SUBJECT: NW CORNER OF INDIAL Pk + UNIVERSITY AVE J15  
(PROPOSED APT COMPLEX) DRD 84-40

Re: Drainage Report for Netherwood Apartments

RE: DRAINAGE REPORT FOR NETHERWOOD APARTMENTS  
(J15-D20) RECEIVED MARCH 13, 1984

EROSION CONTROL PLAN

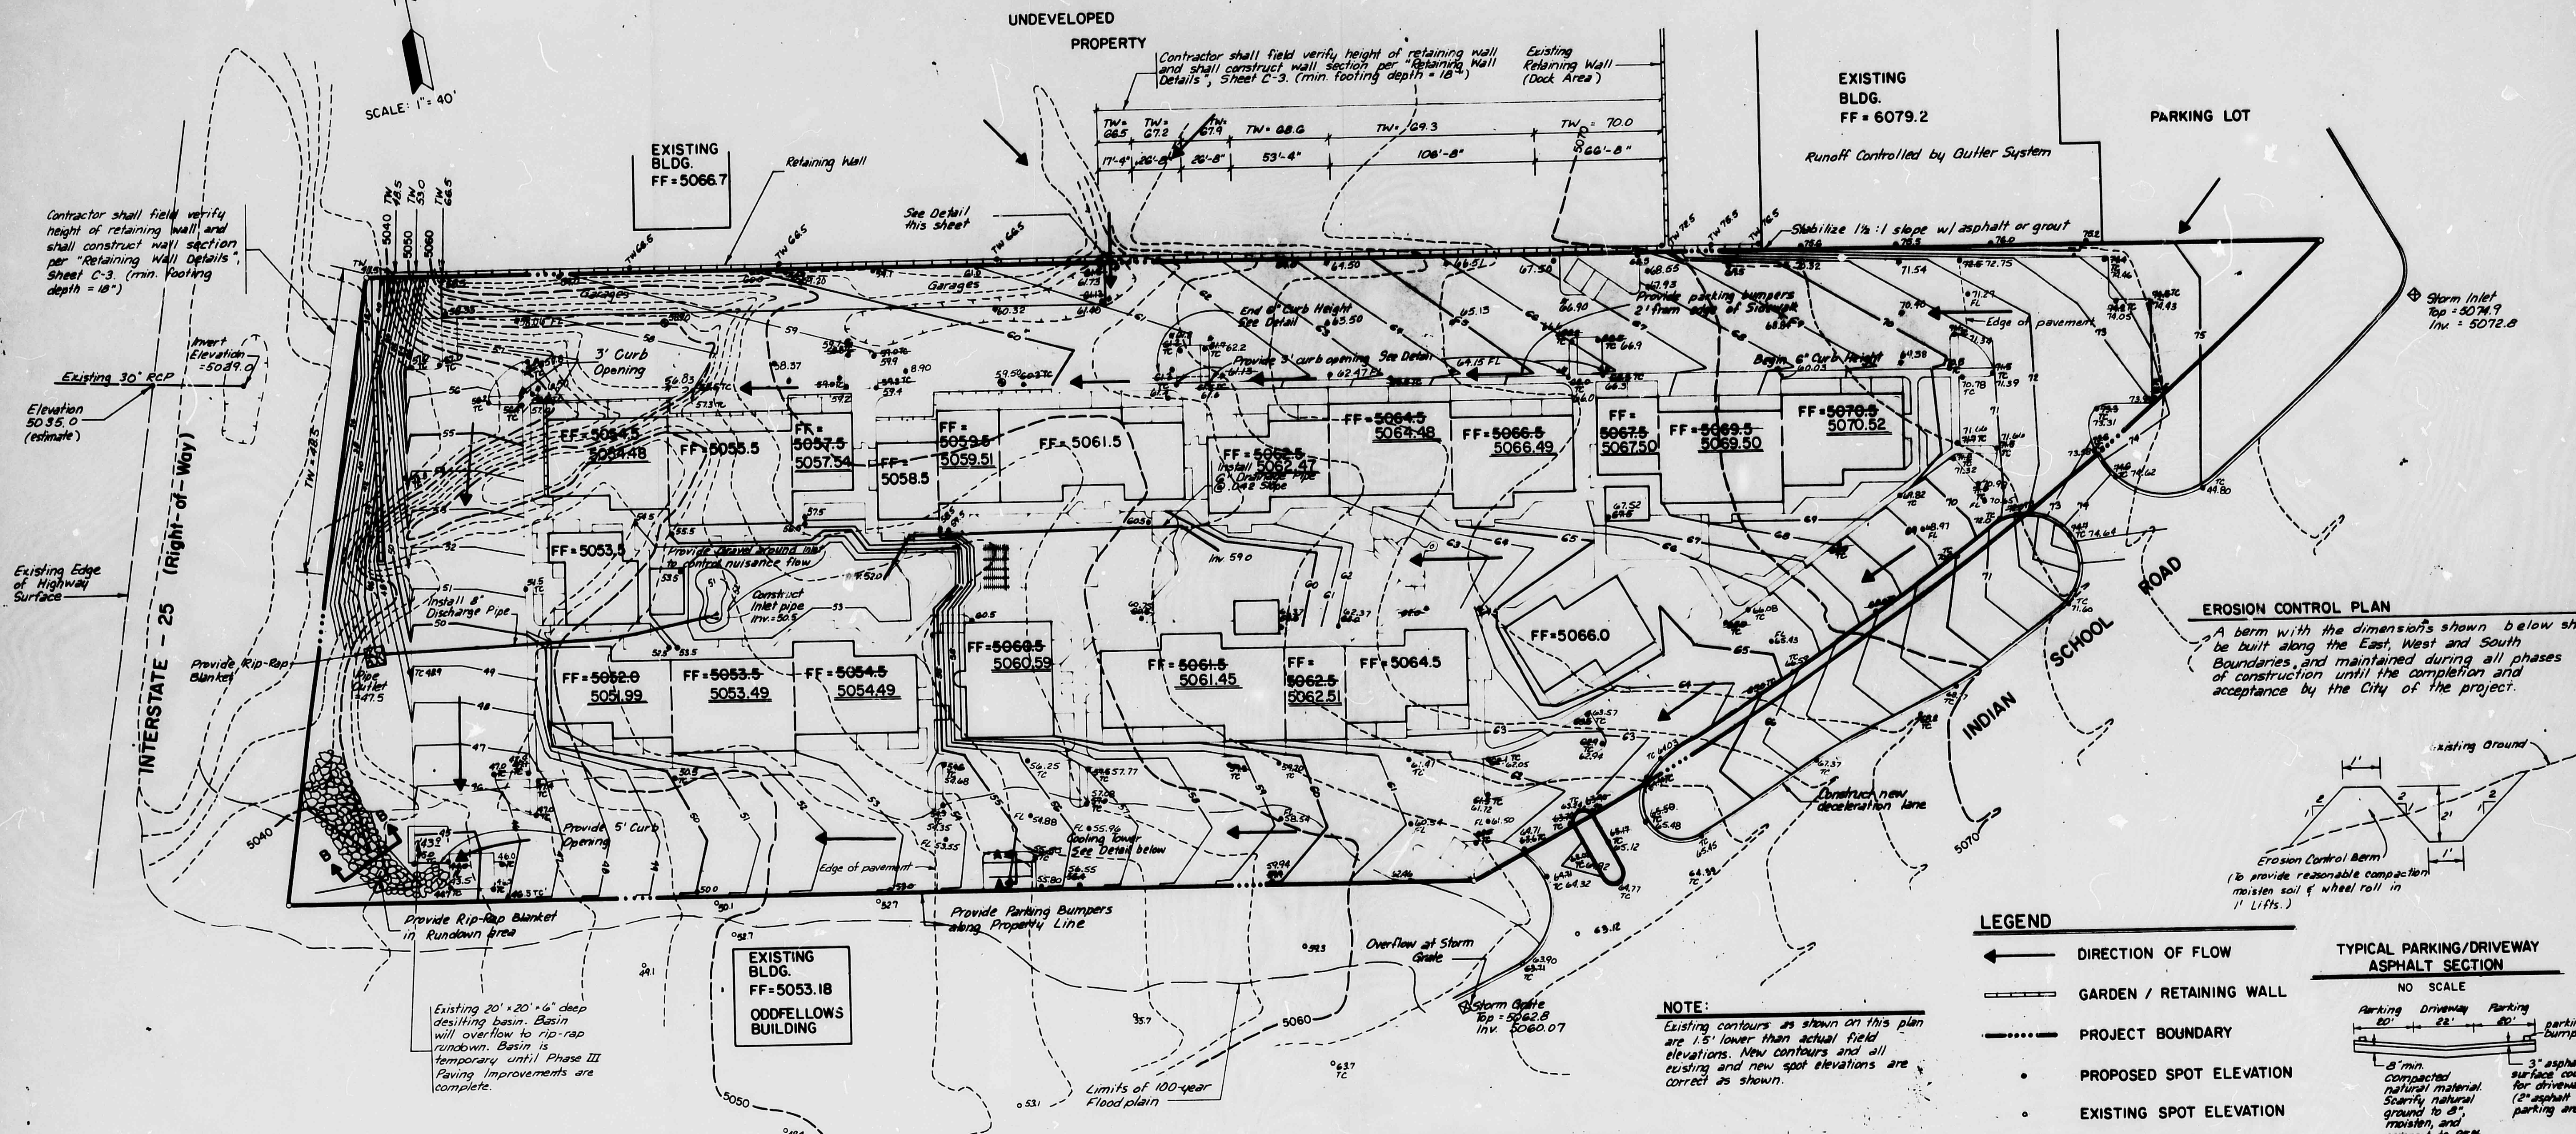
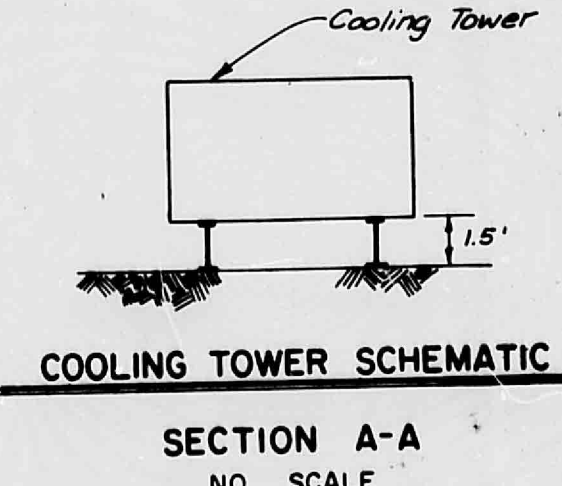
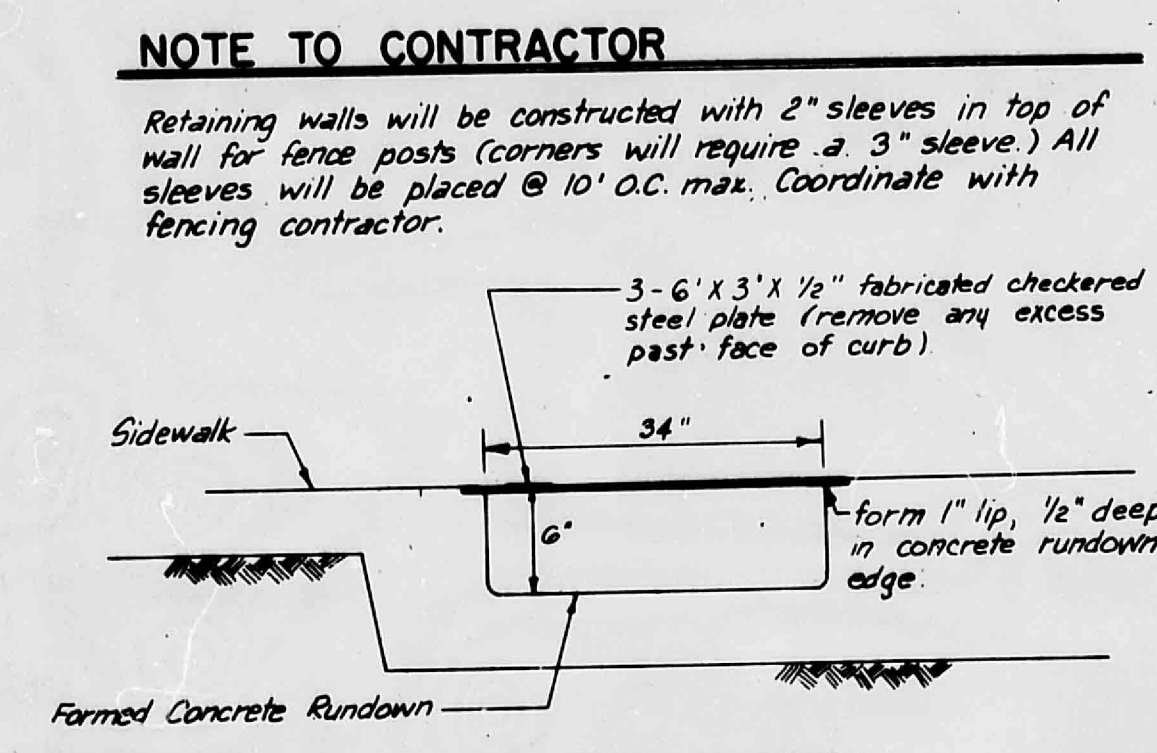
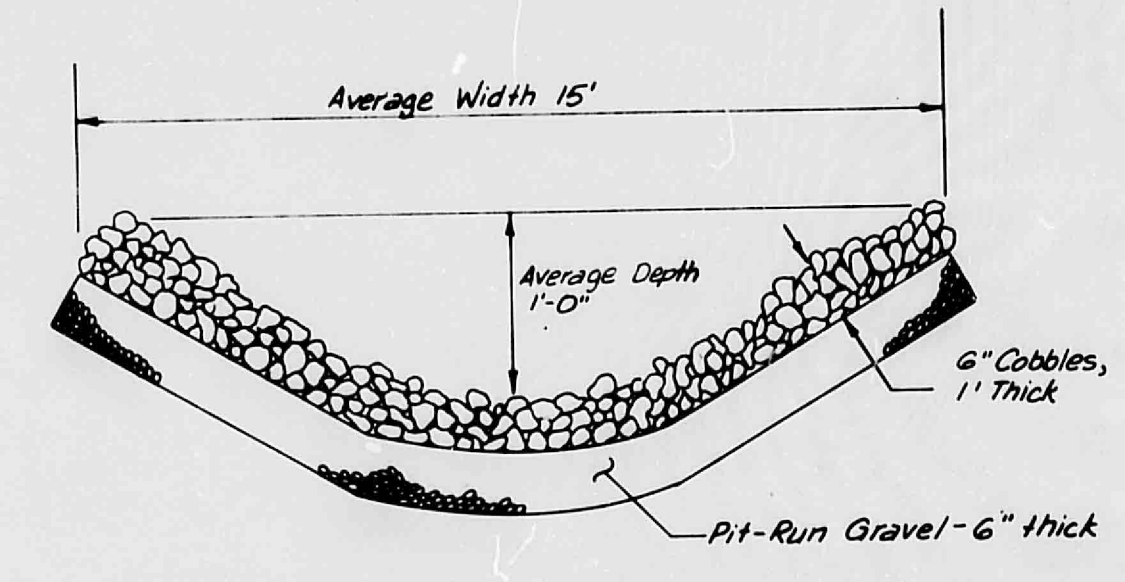
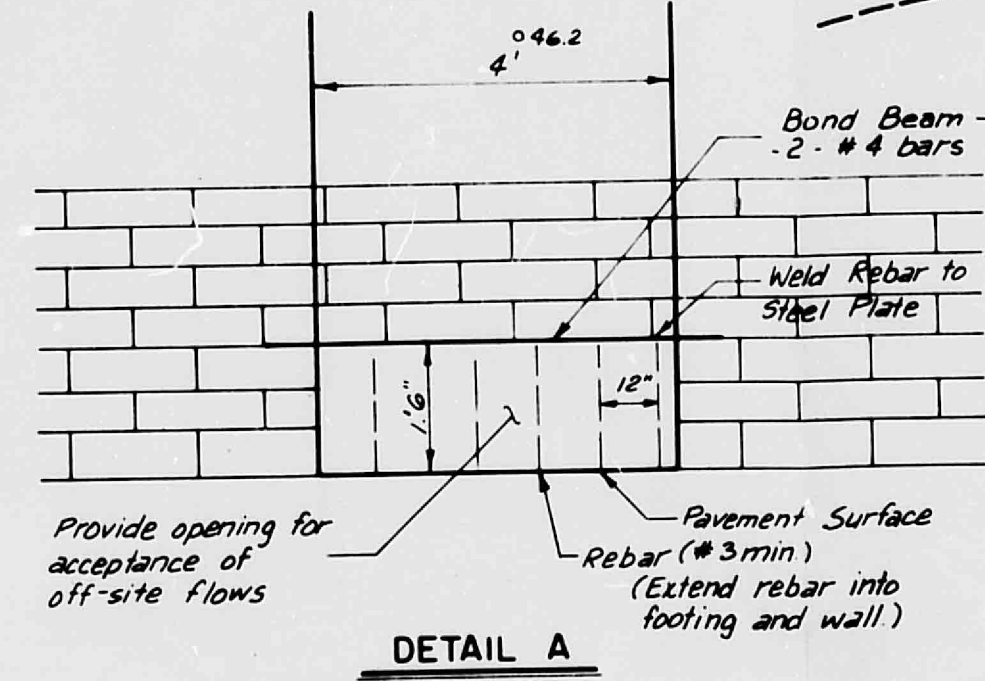
1. How much ponding will be required for the flow through the 30" pipe under I-25? Will the water surface be within 15 feet of a structure or the asphalt for the highway?

2. What are the characteristics of the pond on-site, i.e., volume, water surface elevation? What are the outlet pipe characteristics?
3. What are the hydraulics associated with the gravel rundown? How does the water get into it? Will the momentum around the curve cause piracy? What is the outlet velocity? Will erosion occur? It is suggested that the outlet be fanned to spread the water and minimize the concentration.

4. Weep-holes, as per City standard, should be provided in the retaining walls where a ~~previous~~ area is on the high side to reduce hydrostatic pressure.

5. Details for the curb cuts should be provided or City standard cited.
6. It was requested in the pre-design conference that the flood plain along the south property line be shown. This has not been indicated.

1. The invert elevation of the 30" RCP is approximately 5029.0. To avoid damage to the retaining wall, ponding must not occur higher than the 5032.0 contour. I have estimated that approximately 45,000 cu. ft. of storage is provided between the 5030.0 and 5032.0 contour. Utilizing the 100-year runoff hydrograph (see enclosed), and the fact that a 30" RCP can convey 31 cfs with a head of 1.75 feet (0.5 feet above the top of the pipe), approximately 50,000 cu. ft. of storage is required. In my opinion, this provides a reasonable match.

2. Roof drains for the project will be directed toward the front to a paved surface. Except for the pool area, the internal basin contributing to the pond is grass or landscaped surface. This basin is approximately 700 feet long and 70 feet wide, or a total area of 1.12 acres. Assuming a 'C' factor of 0.4 ('B' type soil and 14% impervious), approximately 2.06 cfs is generated during the 100-year storm. An 8" pipe with 2.67 feet of head can convey approximately 2.75 cfs. It is not anticipated that runoff will pool in the small depressed area. If the system becomes clogged, runoff will be conveyed between two buildings. The finished floor of the most southerly building has been raised 0.5 feet to insure that runoff remains out of the structure.

3. Approximately 4.0 acres on-site contribute to the rundown system along with 4.3 cfs of off-site flow. A total flow of 23 cfs is anticipated at the rundown during the 100-year storm (buildings have not been included in the runoff computations since the roofs act like detention ponds releasing runoff at a minimal rate). A 10-foot by 16-foot deep triangular

shaped rundown can convey about 35 cfs. Since a 15-foot facility has been provided, ample capacity exists. The associated velocities for the 100-year flow are in the 6-8 fps range and do not appear excessive. However, to prevent potential erosion, riprap has been extended to the property line and fanned to minimize concentration of flows. Due to the width of the rundown, piracy is not anticipated.

4. The retaining walls will be constructed to City standards and will include weep holes.
5. A curb opening detail has been provided.
6. The 100-year flood plain has been indicated on the plan. I apologize for the oversight.
